**Attention: Director, Infrastructure Projects - North West Rail Line - EIS 2 (SSI-5414)**

I write with reference to the opportunity to provide comment on the second Environmental Impact Statement relating to the construction of the North West Rail line – application no. SSI-5414.

Figure 6.16 Castle Hill Station – Indicative vehicle and pedestrian movements

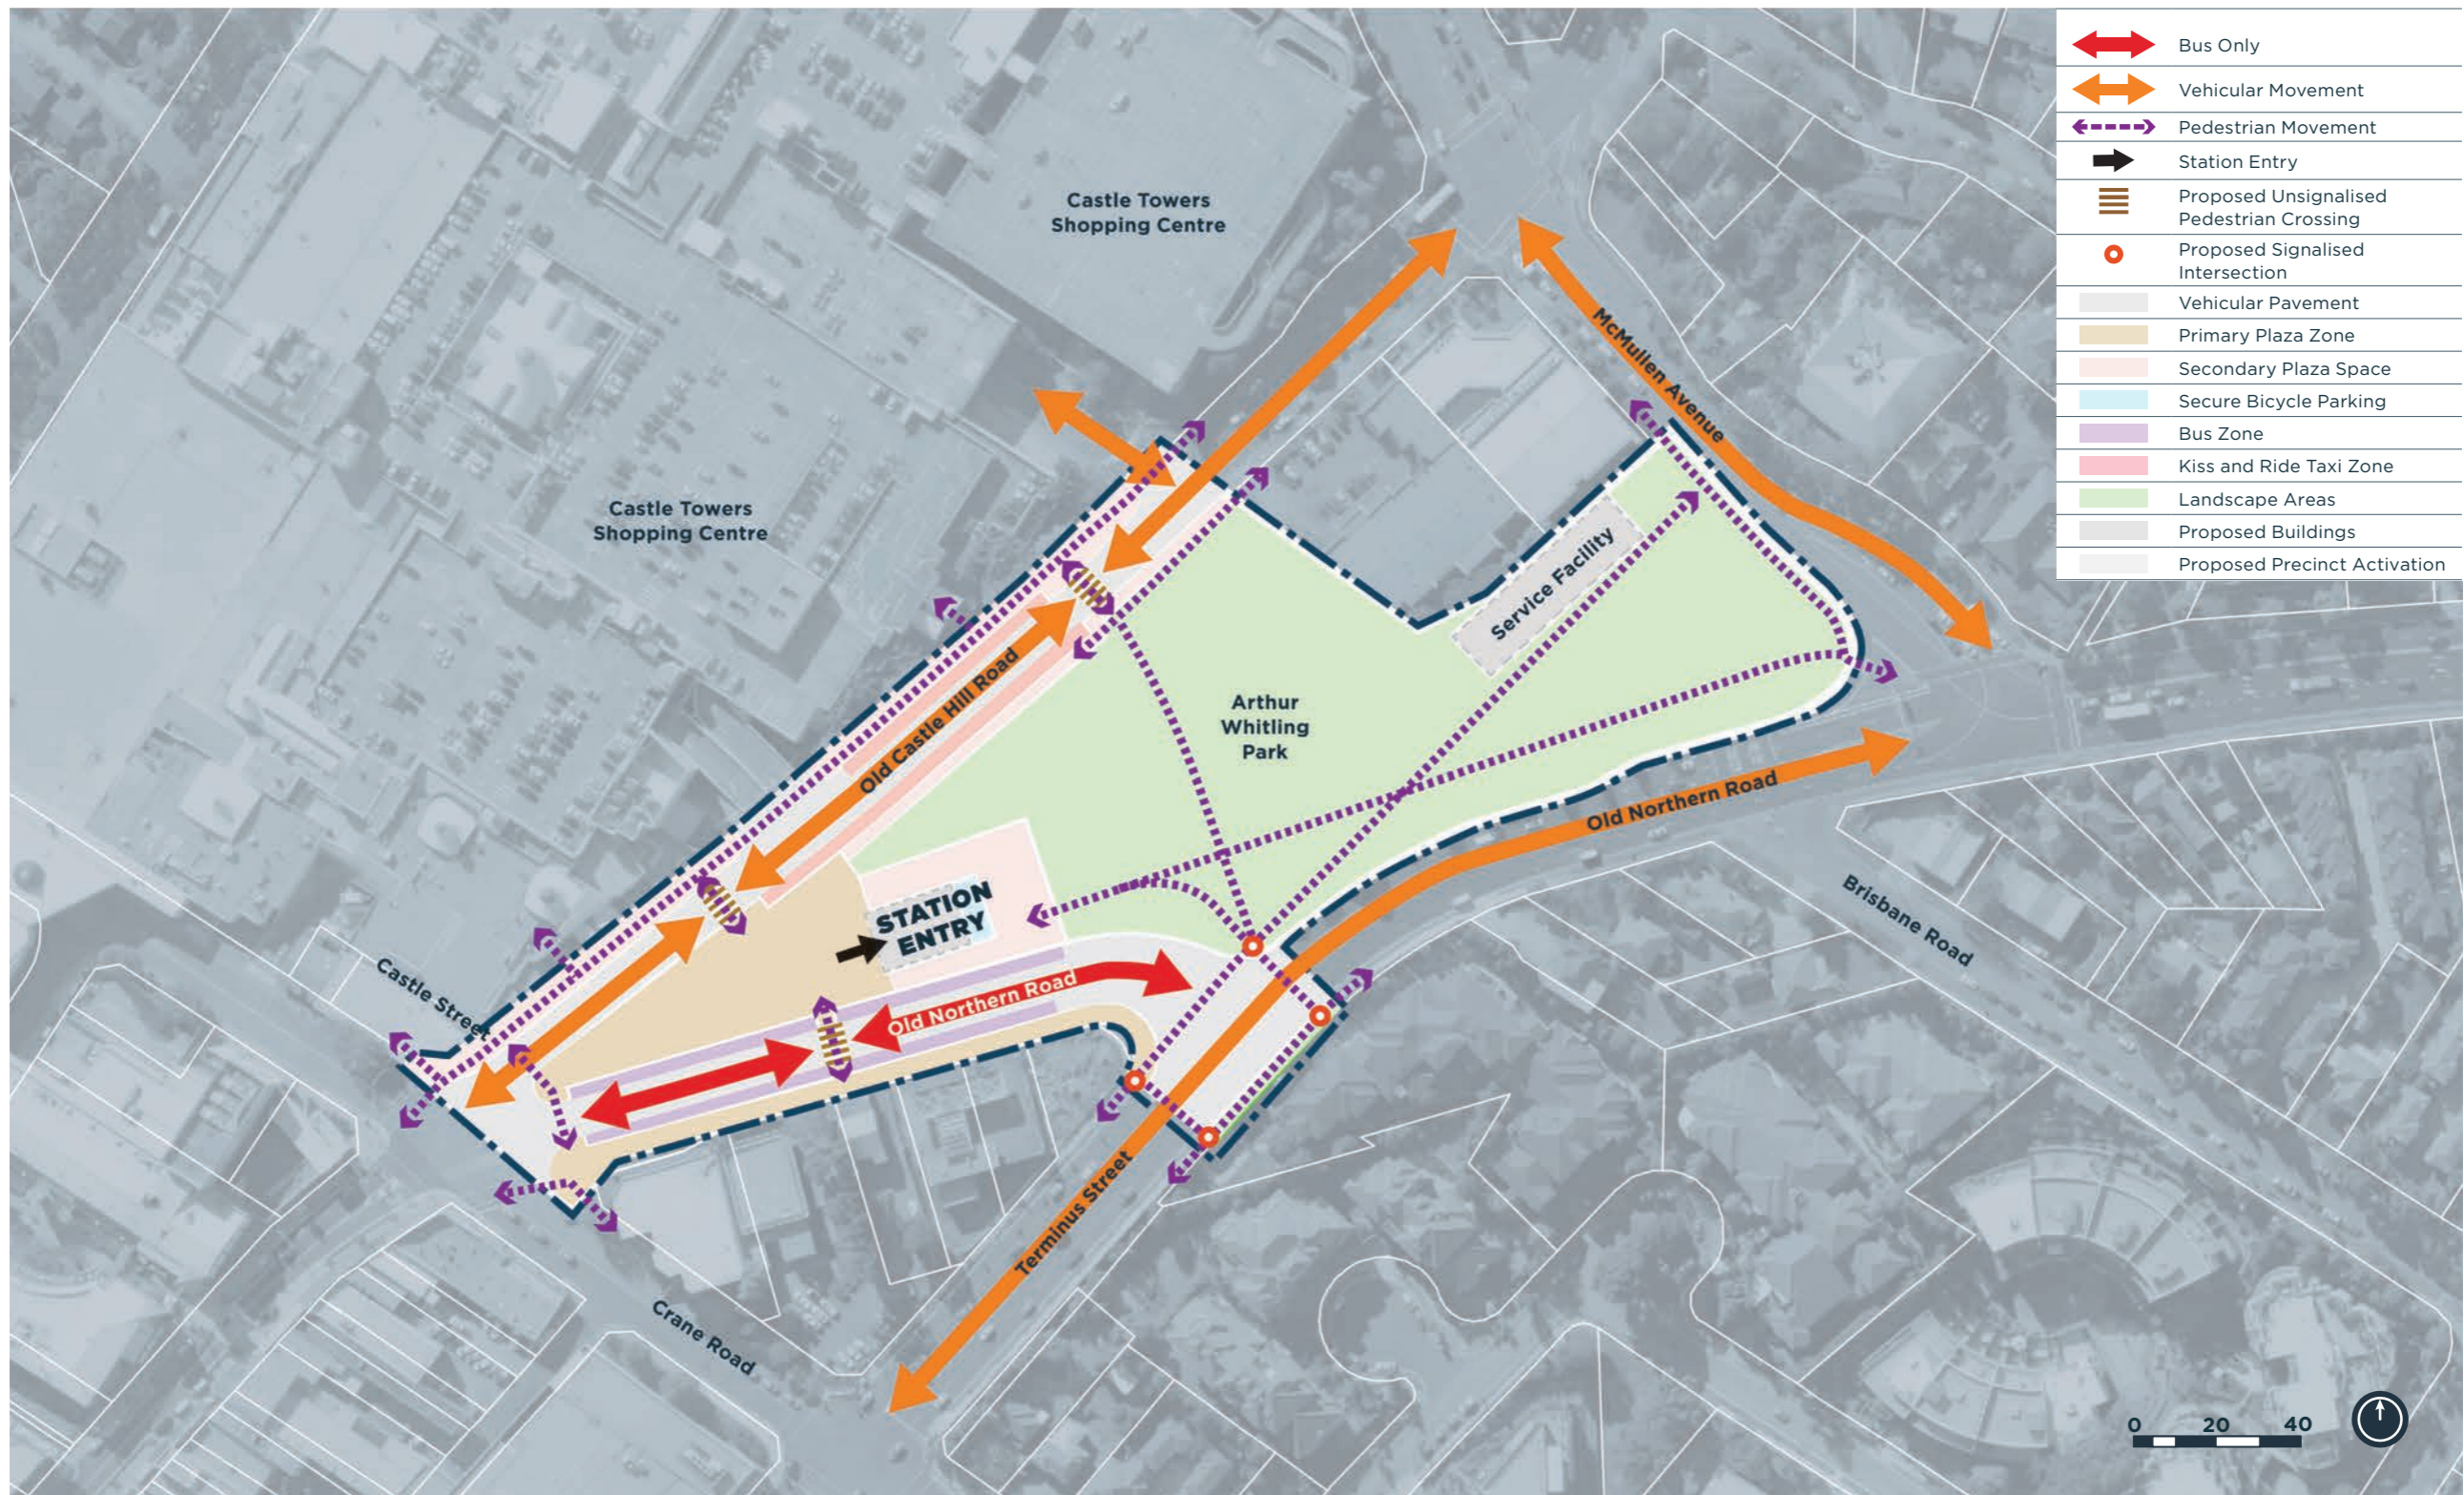
The high demand for bus layover is referred to within numerous sections of the EIS. Further, it has been correctly identified that currently layover occurs on the south-eastern side of Castle Hill Rd – in the **immediate** vicinity of the departure ranks, which are directly opposite. (EIS 2 – Overview pg. 62)

It is the strong co-location of bus layover space and arrival/departure ranks that facilitates efficient bus operations within this busy bus hub.

**Post construction** however, it would be profitable to return to an earlier proposal to retain some bus ranks in Old Castle Hill Rd...this was the subject of former studies on a proposed bus interchange in Castle Hill.

Importantly, and in addition to affording increased predictability for public transport users, this proposal also allows for a small amount of short term layover within both Old Northern Rd and Old Castle Hill Rd.

The ranking arrangement that I have proposed in Old Castle Hill Rd also allows Busways bus services, owing to their origin/destination, a short, predictable and efficient route from and to Showground Rd via: <L> Pennant St, <R> Old Castle Hill Rd, <RANK>, <R> Castle St, and <L> Pennant St.

Figure 4 Castle Hill station – heavy vehicle routes

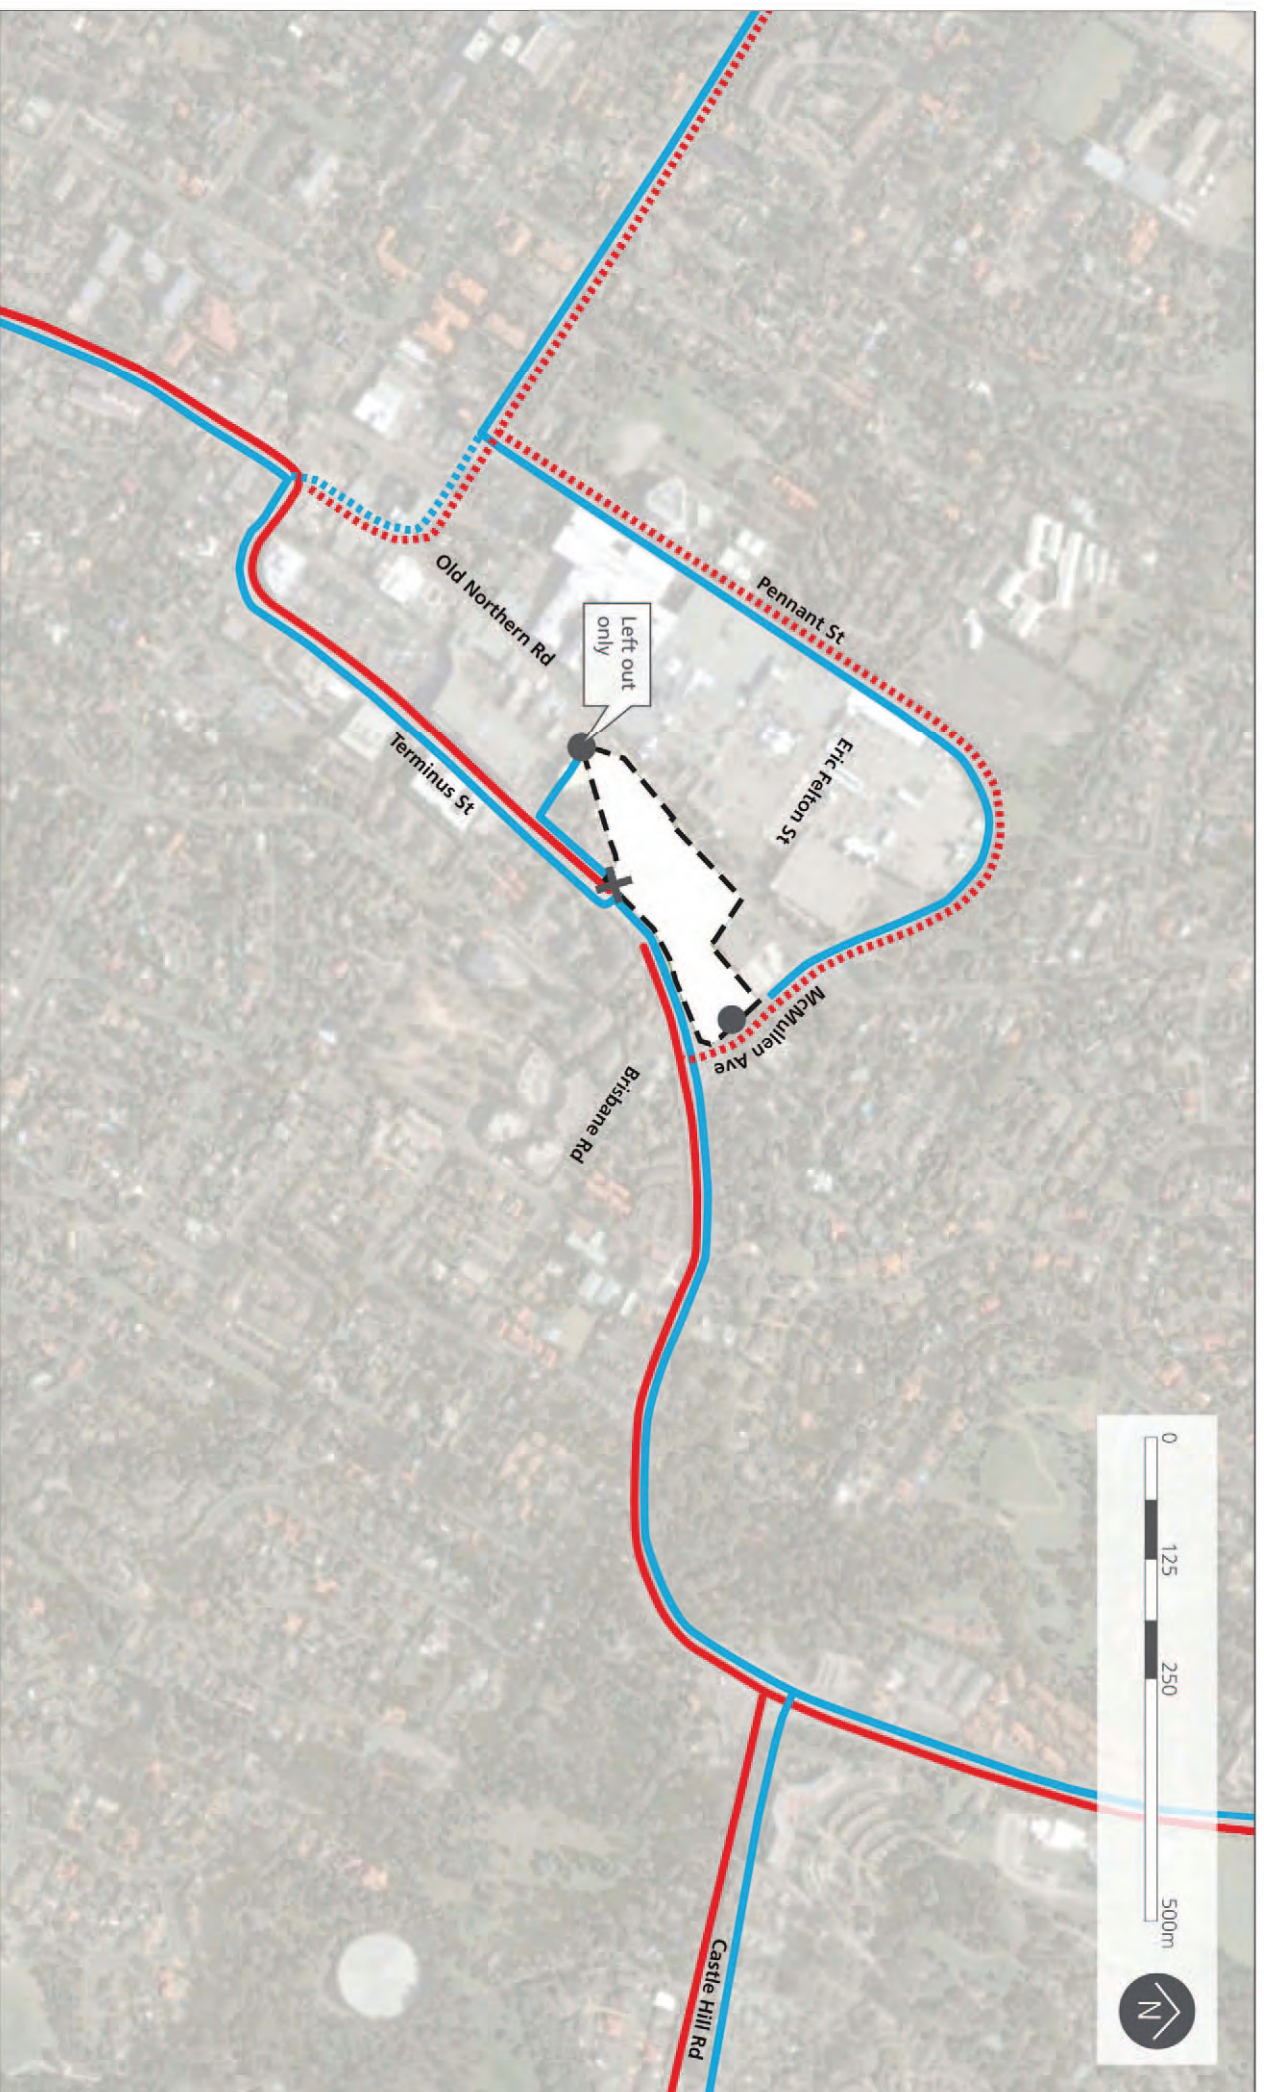
The report (EIS 2 – Construction Traffic Management pg. 39) also noted that the performance of the signalised intersection of Old Castle Hill Rd/Pennant St/McMullen Ave is expected to deteriorate and bottom out at LoS F. Given the huge number of buses exiting Old Castle Hill Rd via this intersection, consideration must be given to diverting construction traffic away during the morning and afternoon peaks.

In the worst case scenario, queuing from this intersection could extend back along Old Castle Hill Rd beyond Eric Felton St, and hence impact on the bus interchange.

Figure 6.36 Rouse Hill Station - Indicative vehicle and pedestrian movements

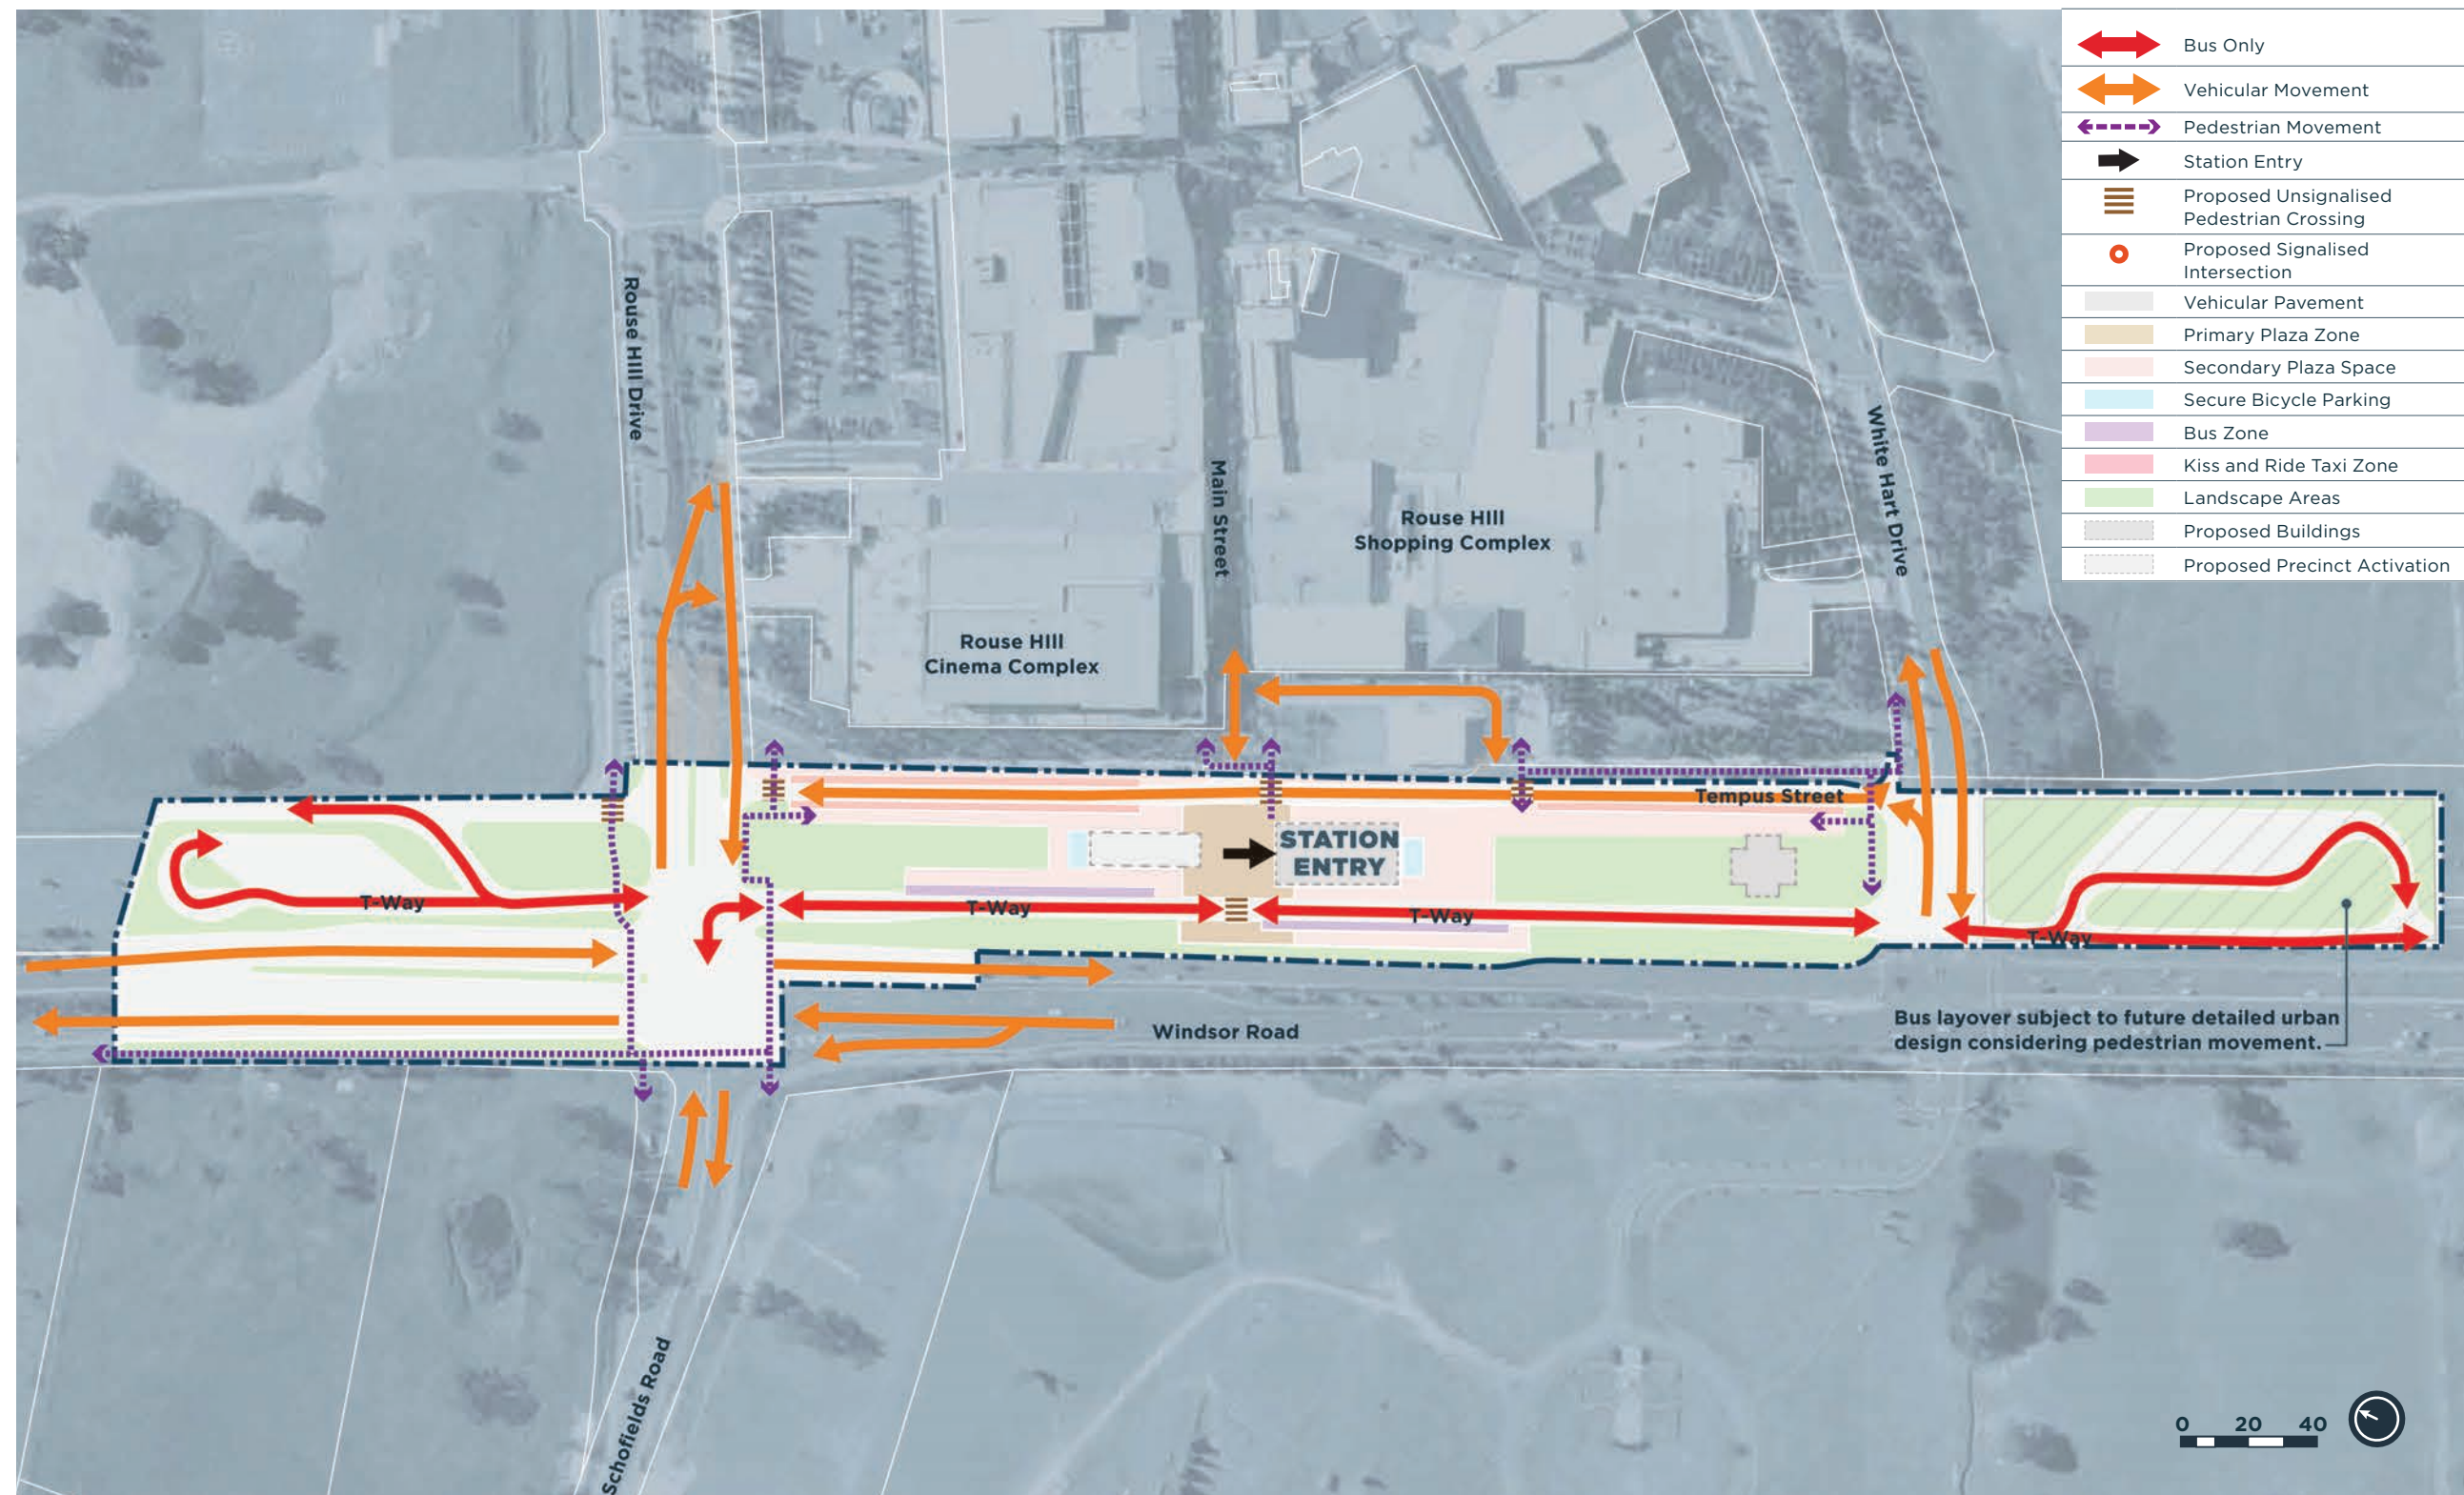
In view of the concentration of bus services at RHTC, and the intention to provide bus layover remote from the operational bus ranks, as at Castle Hill, (EIS 2 - Traffic and Transport pg. 9-37), an identical set of circumstances relating to short term layover also exists at this location.

Hence, all of the abovementioned comments relating to the proximity of short term layover parking to the operational bus ranks (and the provision of bus driver's toilet facilities), are also valid in this instance.

Should the northern layover area be the site of the *only* toilet facilities provided, then the circuitous route to and from this site will guarantee the late running of buses where bus drivers require access to toilets during most short term layover.

It is noted in section **4.10.3 Heavy Vehicle Routes** (EIS 2 – Construction Traffic Management pg. 69) that entry into RHTC from the north is proposed to be via a left turn into White Hart Dr from Windsor Rd, followed immediately by another left turn into the construction access road.

Given the opposing movement of buses on the construction access road at that location, consideration should be given to modifying the kerb-returns of the inner radius of the turn to safely accommodate the turning paths of heavy vehicles.

**A critical component of this, and hence worthy of independent mention, is that a right hand turn for buses from the T-way (northbound) to White Hart Dr (eastbound) will be required.** As such, this must be modelled and incorporated into the enabling works for the construction at RHTC.
